File No: NTH18/00047/11  
Your Ref: SSD10353

**Re: Review of EIS for Tweed Valley Hospital – Stage 2. - Major Project SSD10353.**

I refer to your email dated 4 October 2019 requesting comment from Roads and Maritime Services in relation to the above mentioned EIS for the construction of the Tweed Valley Hospital (stage 2 of the project).

NOT FOR CONSTRUCTION

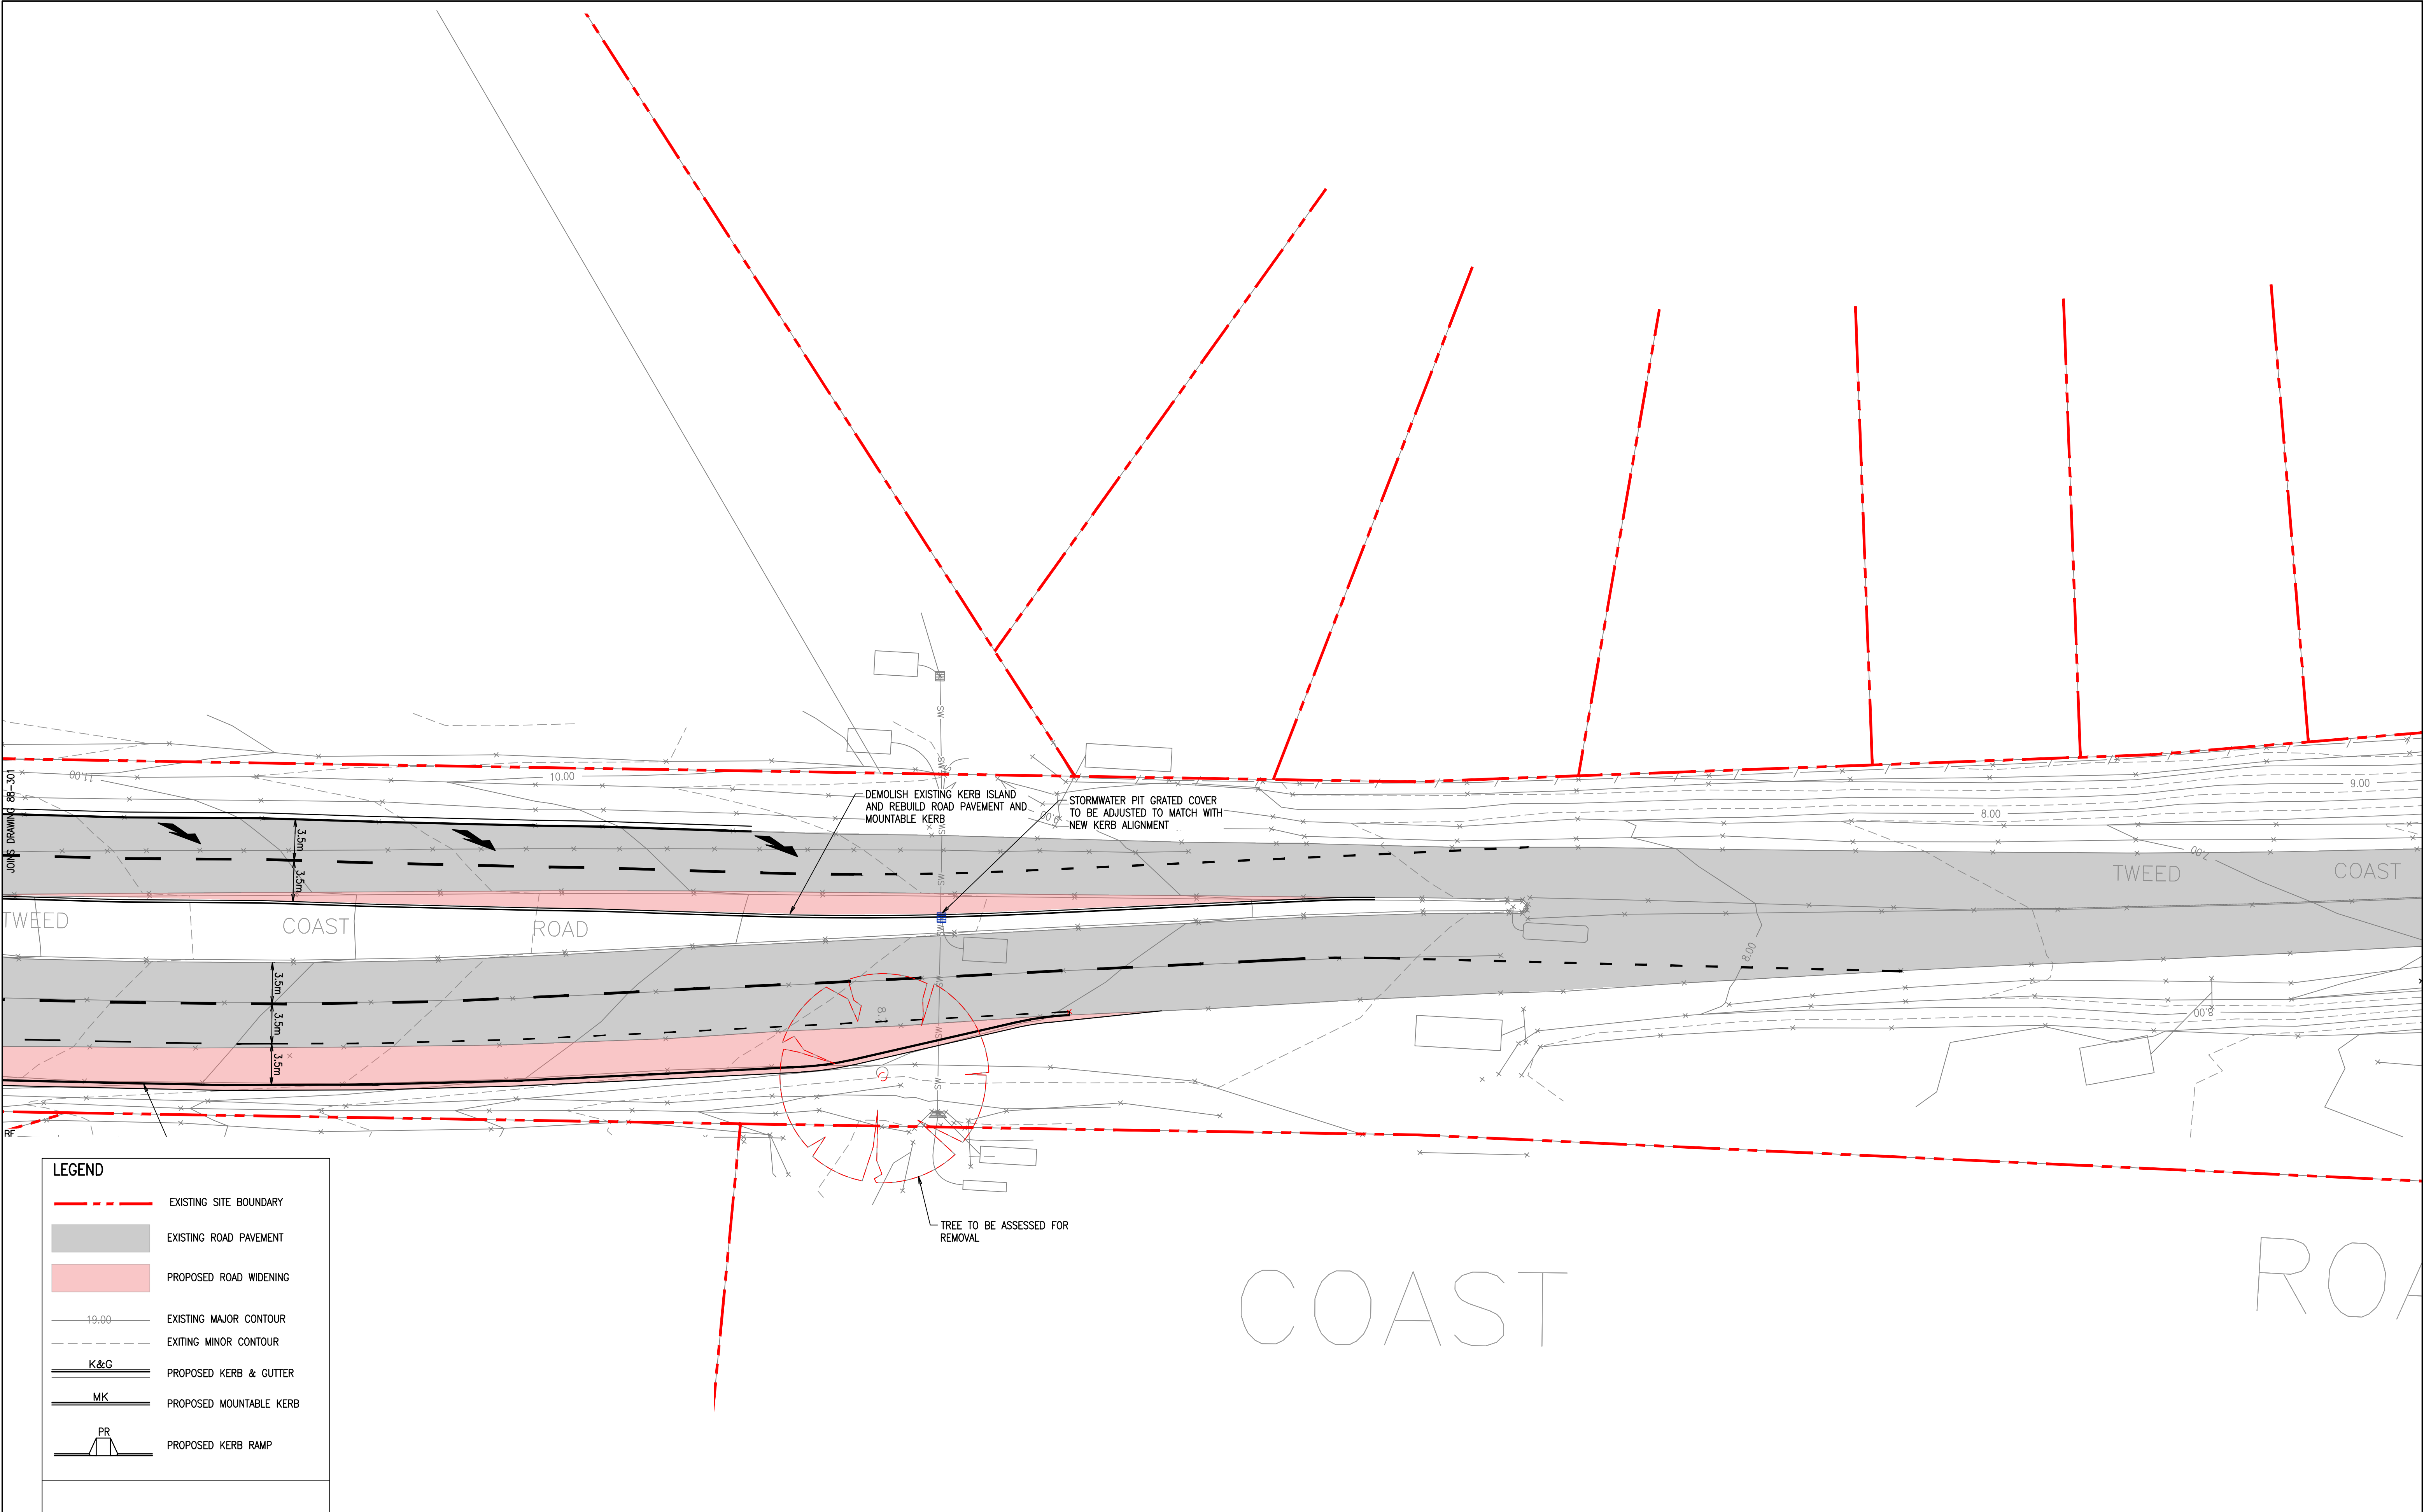
- Stage 1 consent condition B22 (c) requires plans for the upgrade for Tweed Coast Road/Cudgen Road intersection. The plans provided for stage 2 have no dimensions and should be updated to include the additional lengthening of the Tweed Coast Road north-bound right-turn bay, and left-turn deceleration lanes on Cudgen Road. No detailed plans were provided for the proposed traffic signals at the Hospital entrance.

- Left-turn lanes at the Tweed Coast Road/Cudgen Road at the access into the Hospital should be designed in accordance with Austroads standards. They should be long enough to cater for deceleration and queued traffic due to pedestrian crossings or internal design. For a 60km/h speed zoned area, this would require a minimum of 55m plus queue length.

- Modelling provided with the Stage 2 EIS has indicated that only 20m storage was required for the east-bound left-turn deceleration lane. This should be lengthened to provide 55m to cater for deceleration and queuing back from the hold line as only a single entry lane is provided for both left and right-turning entering traffic into the site. This change should also apply to the four other left-turn slip lanes (east-bound left-turn lane at Tweed Coast Road signals; and the three along the frontage of the site).

- The existing left-turn slip lane for vehicles turning from the western approach to Cudgen Road into Tweed Coast Road has limited storage. SIDRA modelling indicates that this lane needs to provide more capacity. Any queuing will have a significant impact on through and right-turn traffic. It is noted that the northern side is constrained by existing residential. It is suggested that strategic drawings be provided to show queue lengths, and that Council/State Government confirm that those lengths are acceptable and meet Austroads standards.
